From: Michael Eastham <Michael.Eastham@arun.gov.uk>
Sent: 22 April 2021 15:58
To: Planning.Responses <Planning.Responses@arun.gov.uk>
Subject: FW: *EXTERNAL: FW: Water Lane, Angmering - Cond. 9; Noise (Ref. A.39.21.DOC)

Please upload onto Ocella the email below which is a consultation response from **ADC Greenspace** to **A/39/21/DOC**.

From: Sue Howell <Sue.Howell@arun.gov.uk>
Sent: 22 April 2021 15:51
To: Michael Eastham <Michael.Eastham@arun.gov.uk>
Subject: RE: *EXTERNAL: FW: Water Lane, Angmering - Cond. 9; Noise (Ref. A.39.21.DOC)

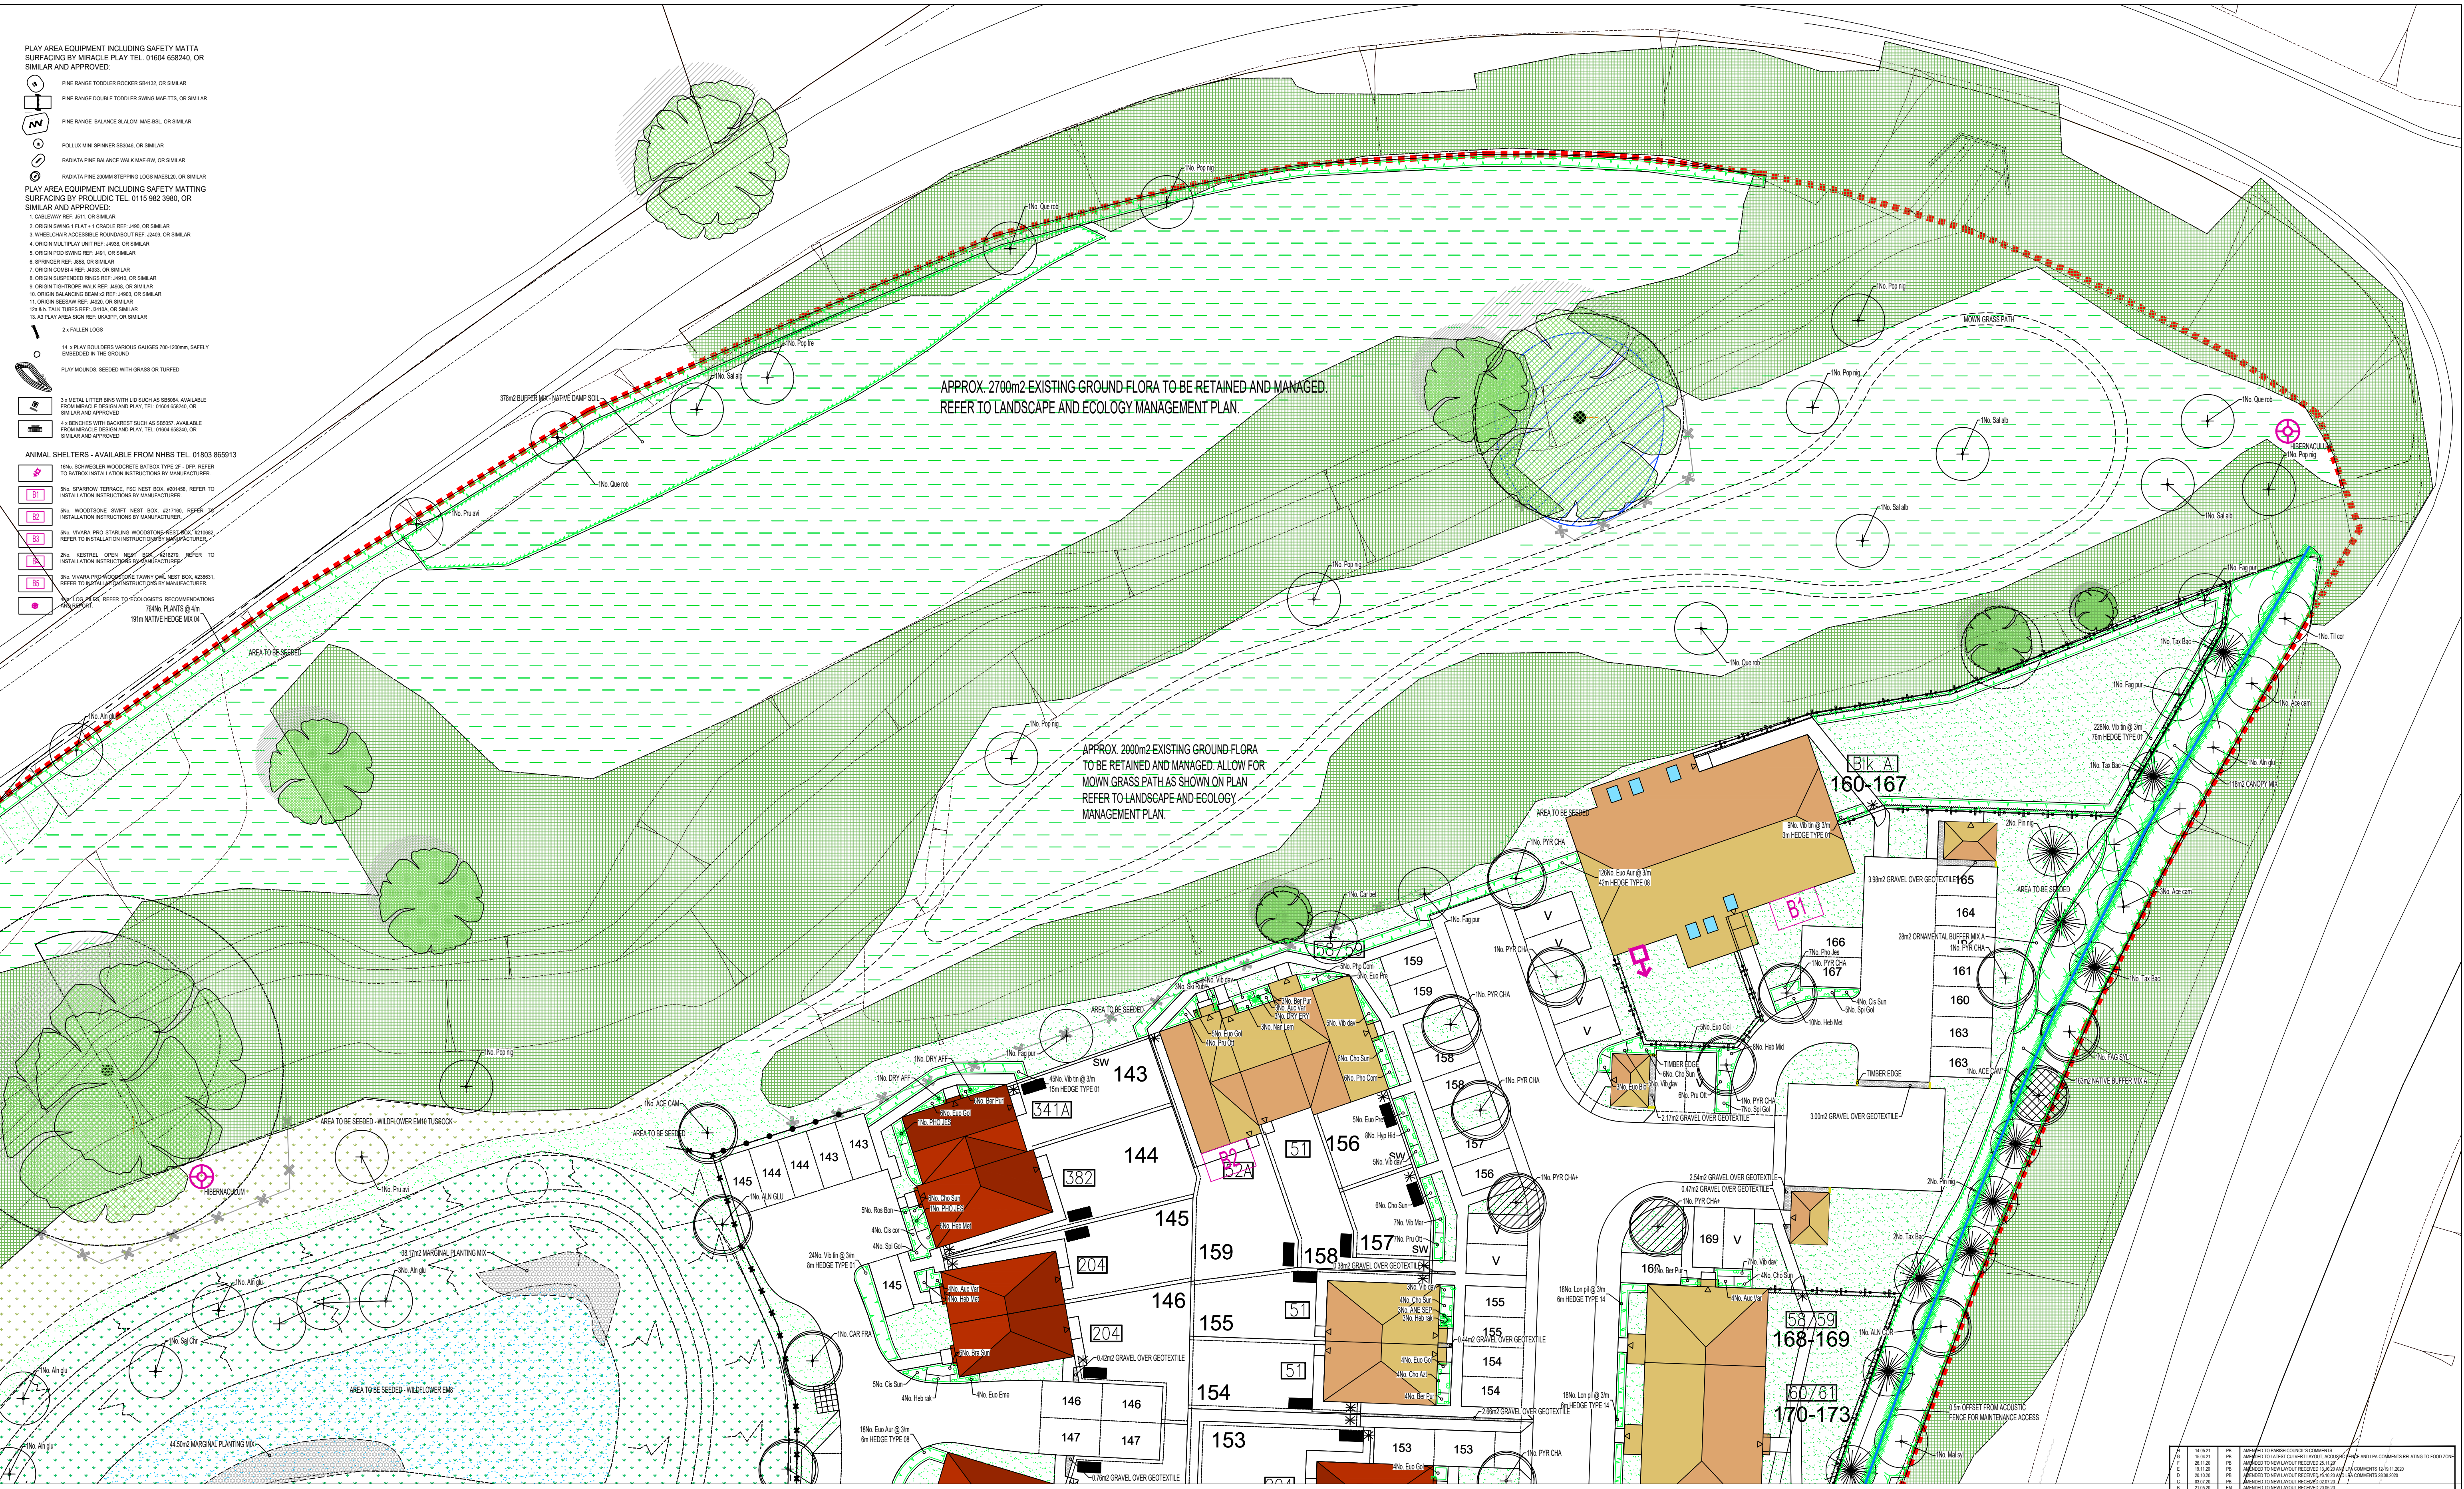
The **JBA 18/019-SK01 BDW PLN-1-5000 Illustrative Landscape Masterplan** indicates a bold blue hatched line along the more northern section of the bund but no annotation as to what this is? Is this the acoustic fence? There is no detail in the legend as to what this is? Then this drawing has a detail which states Acoustic fence along boundary, but this does not show a start or finish point or how metres long?

The **JBA 18/019-SK01 BDW PLN-1-5000 Illustrative Landscape Masterplan** indicates a bold blue hatched line along the more northern section of the bund but no annotation as to what this is? Is this the acoustic fence? There is no detail in the legend as to what this is? Then this drawing has a detail which states Acoustic fence along boundary, but this does not show a start or finish point or how metres long? Apologies, a note was left on from earlier iterations indicating the fence going further south than required. The bold blue hatched line is the extent of the proposed acoustic fence. Although the acoustic fence is annotated within the legend (snippet below), it is referenced as being 30,000mm instead of 3,000mm -- please find the updated plan in the following WeTransfer link: [REDACTED]
